Report of Objections and Comments on behalf of the residents of Poling to Planning Application – A/74/13 Proposed distribution ware house and covered storage, trade counter and associated offices. Upgrading of access road for and improvement of existing junction with the A27

+EL proposed south elevation

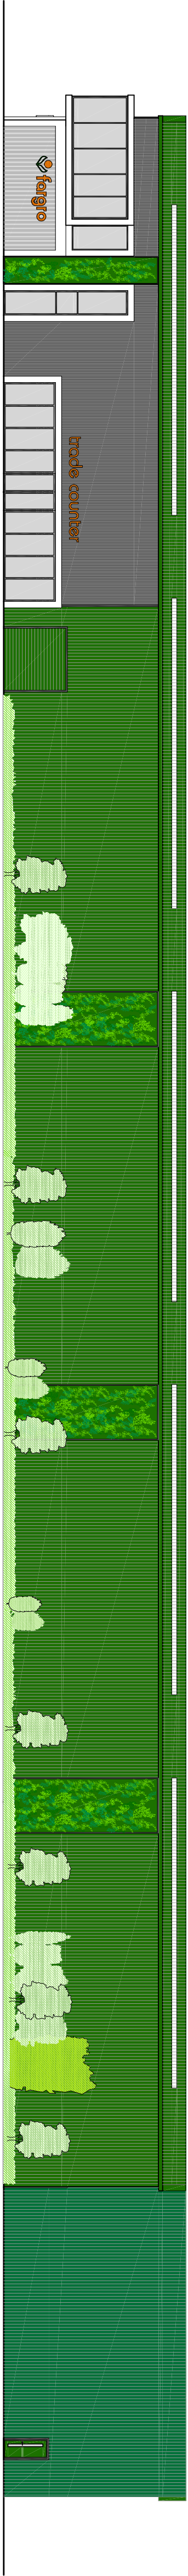
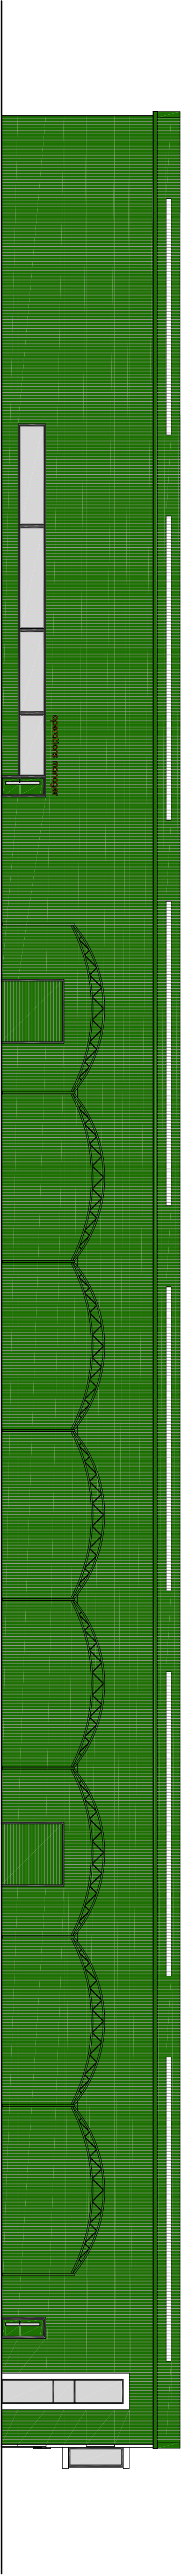
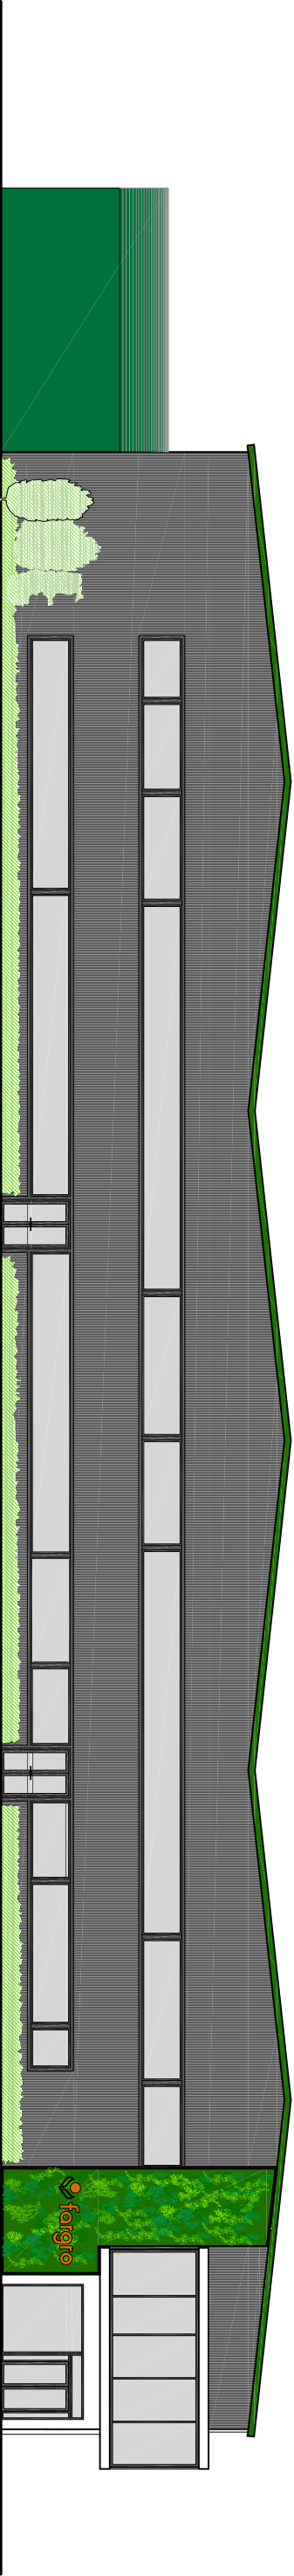
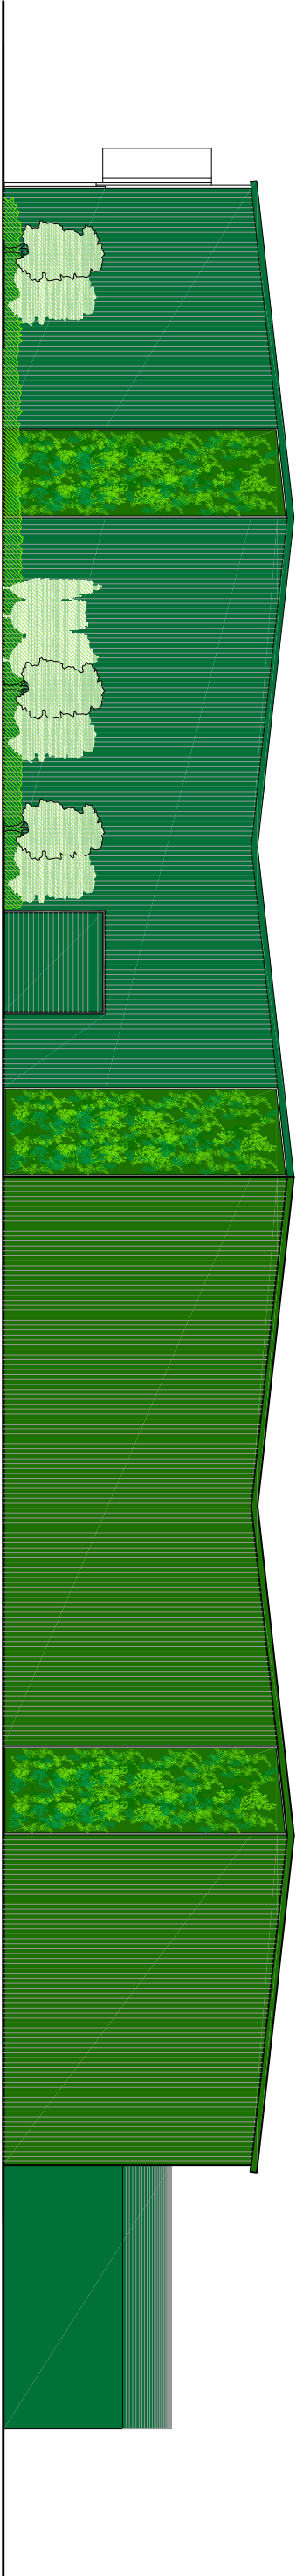
The character and setting of the whole village of Poling with its old and interesting buildings will be massively affected by looking out onto a development of the scale, height and mass of the building proposed by Fargo. The design and materials will be of the usual kind for commercial and industrial buildings and have no place in the countryside.

The proposed new building appear too close to the boundary on the south side. We consider that insufficient space has been left to allow for the growth of the screen of trees noted on the drawings. We also believe that some of the screening shown in the application is on land not owned by the applicant. We therefore consider that application is not sustainable so we ask that it be rejected.

By day the visual effect of the proposed new industrial style building would be an unacceptable intrusion to the enjoyment of the landscape and amenity of the community. The scale and appearance of the proposed buildings would have a significant impact on the environment. The sense of place and character of this rural community, together with the impact on the National Park on the other side of the A27 to the north, is totally unacceptable to us.

The proposed new building would be seen from many publically accessible sites and indeed from many homes. The building profile above the screen of trees will be an incongruous disruption to the view of the heavily wooded National Park. The visual amenity of the village will be disrupted and lost, much the same as the views to the south by the Body Shop building. Surely we can learn from our past mistakes?

Proposed Site Plan

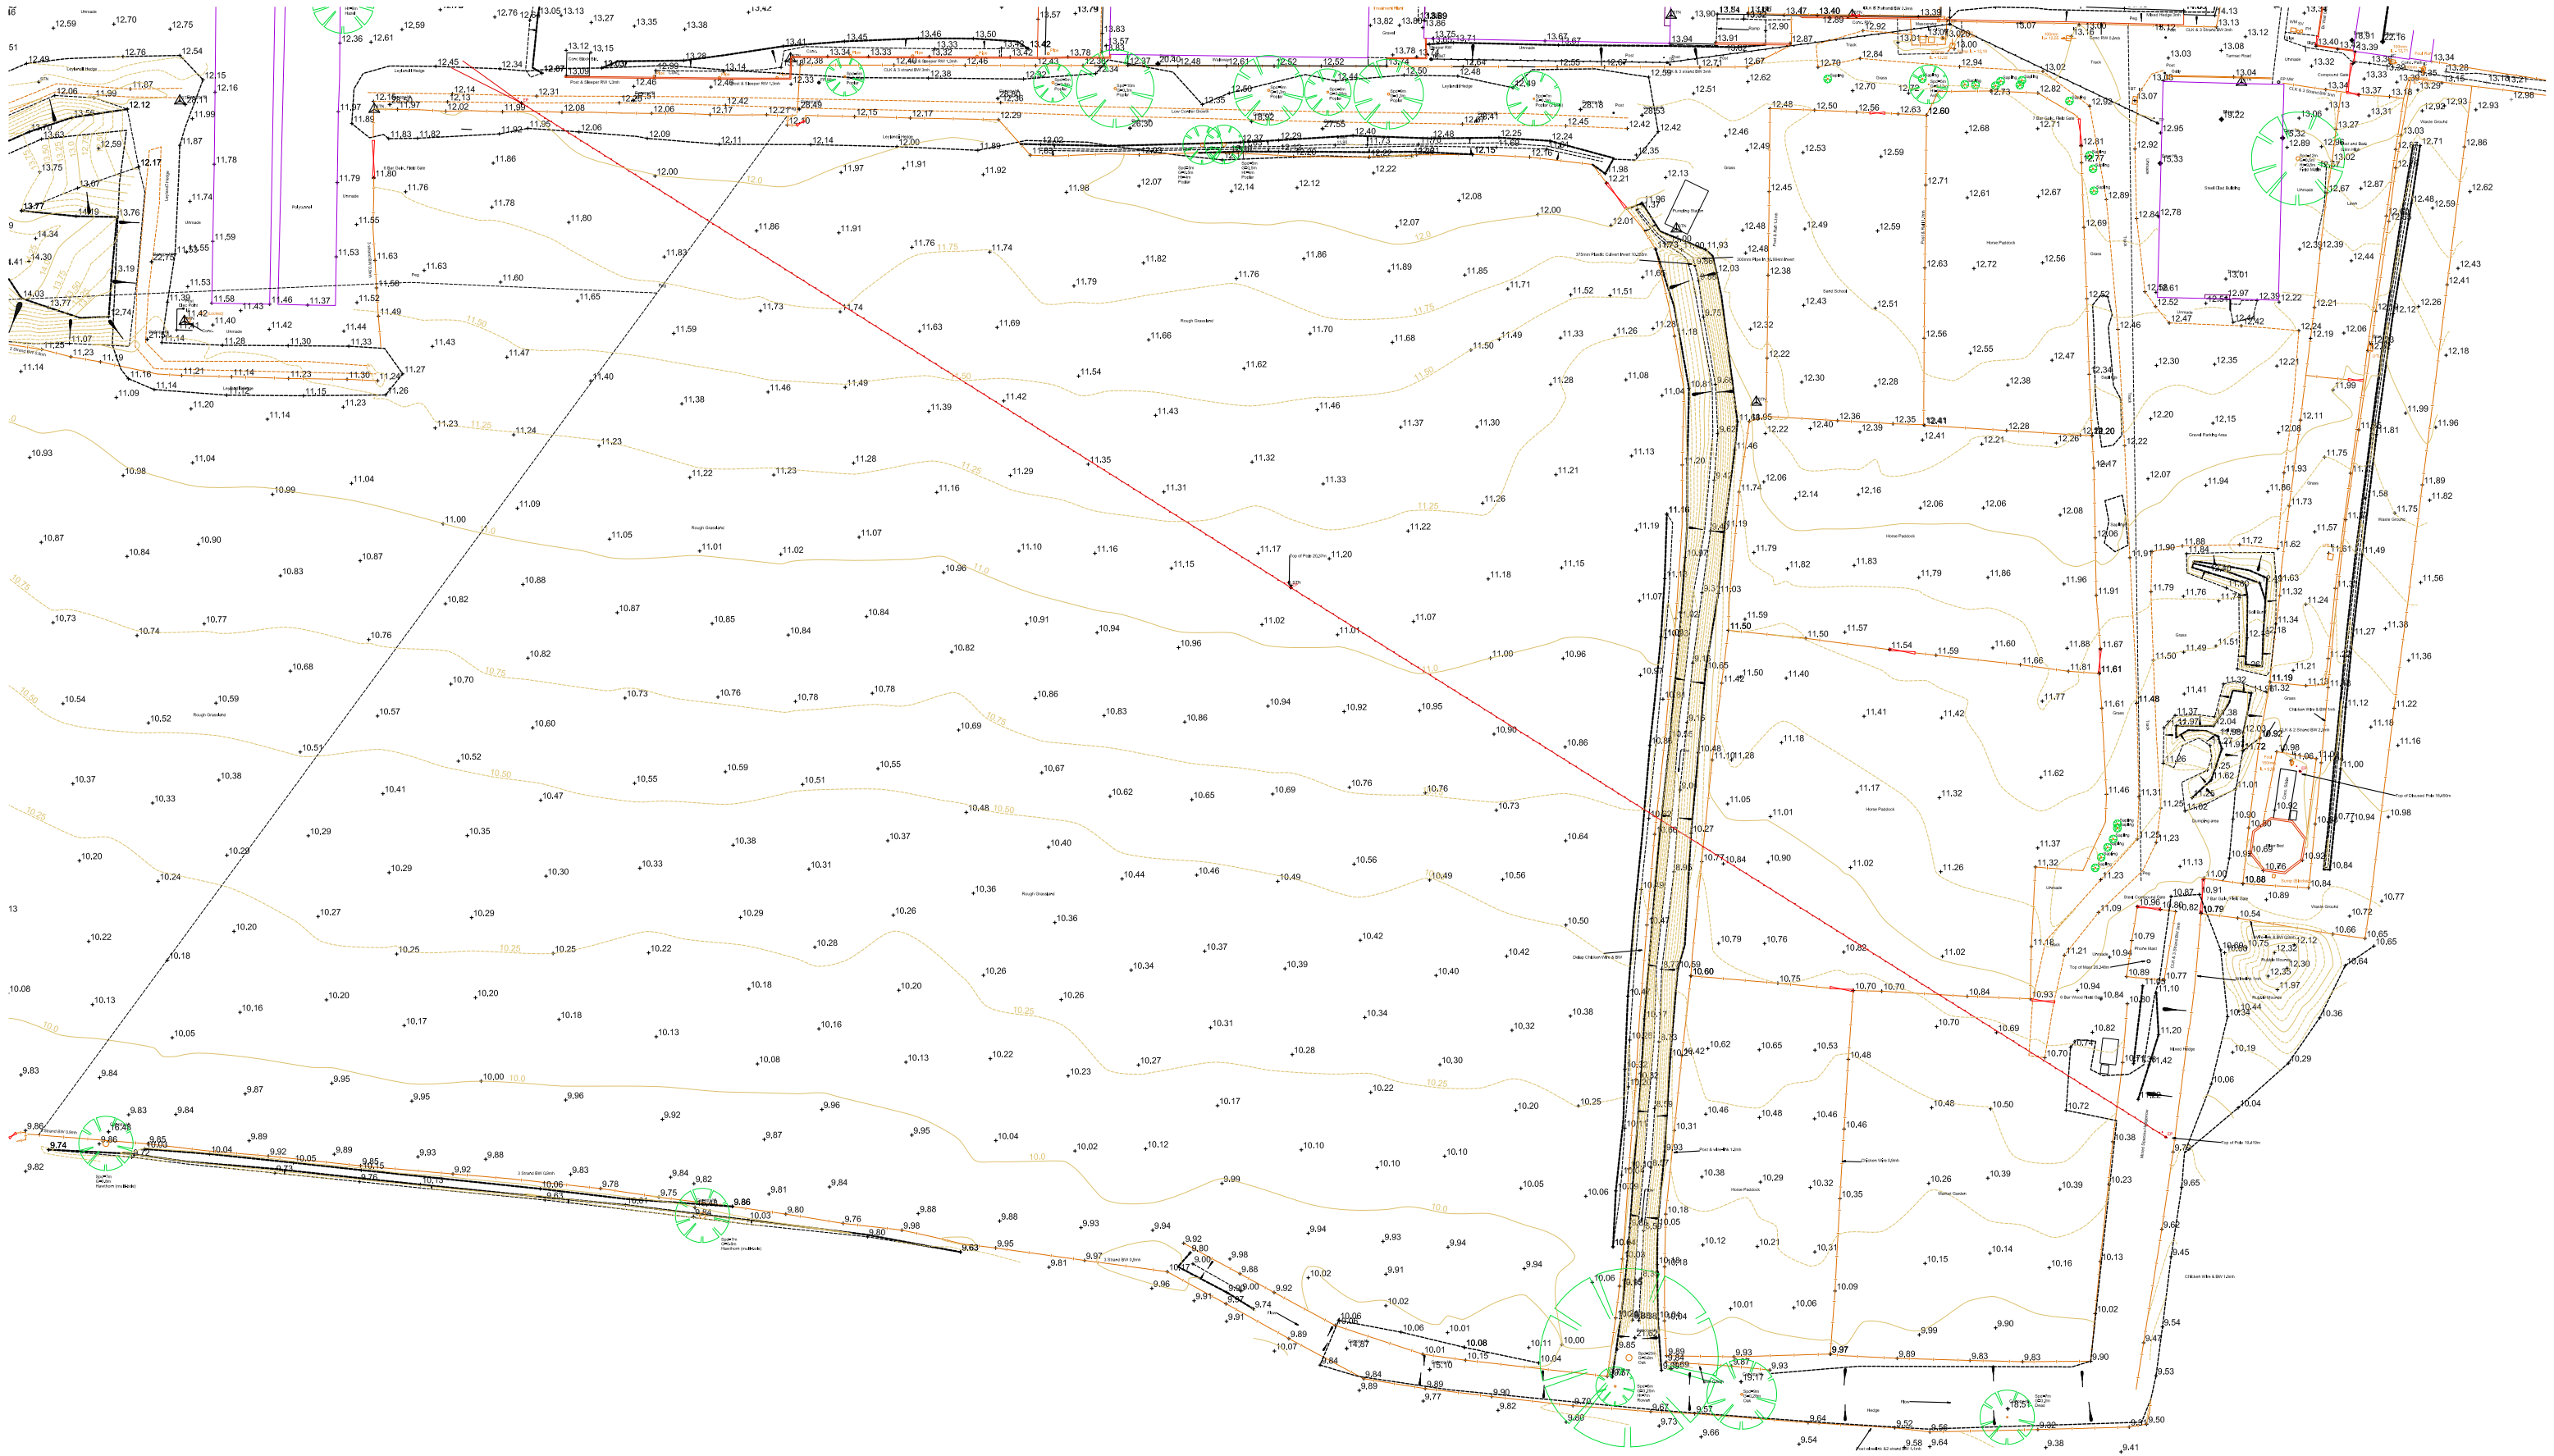
- There are always errors in every application, some of which we have noticed are: that from the drawings it is clear that the development is near to and certainly closer than 20m to watercourses, yet the application highlights that it is not.
- In the Design and Access Statement (D and AS) a number of references are made to the village of Poling being remote and over ½ mile away, which is not true as parts of the village are only as much as 350m away.
- The D and AS is incorrect as there is no public transport along the A27.
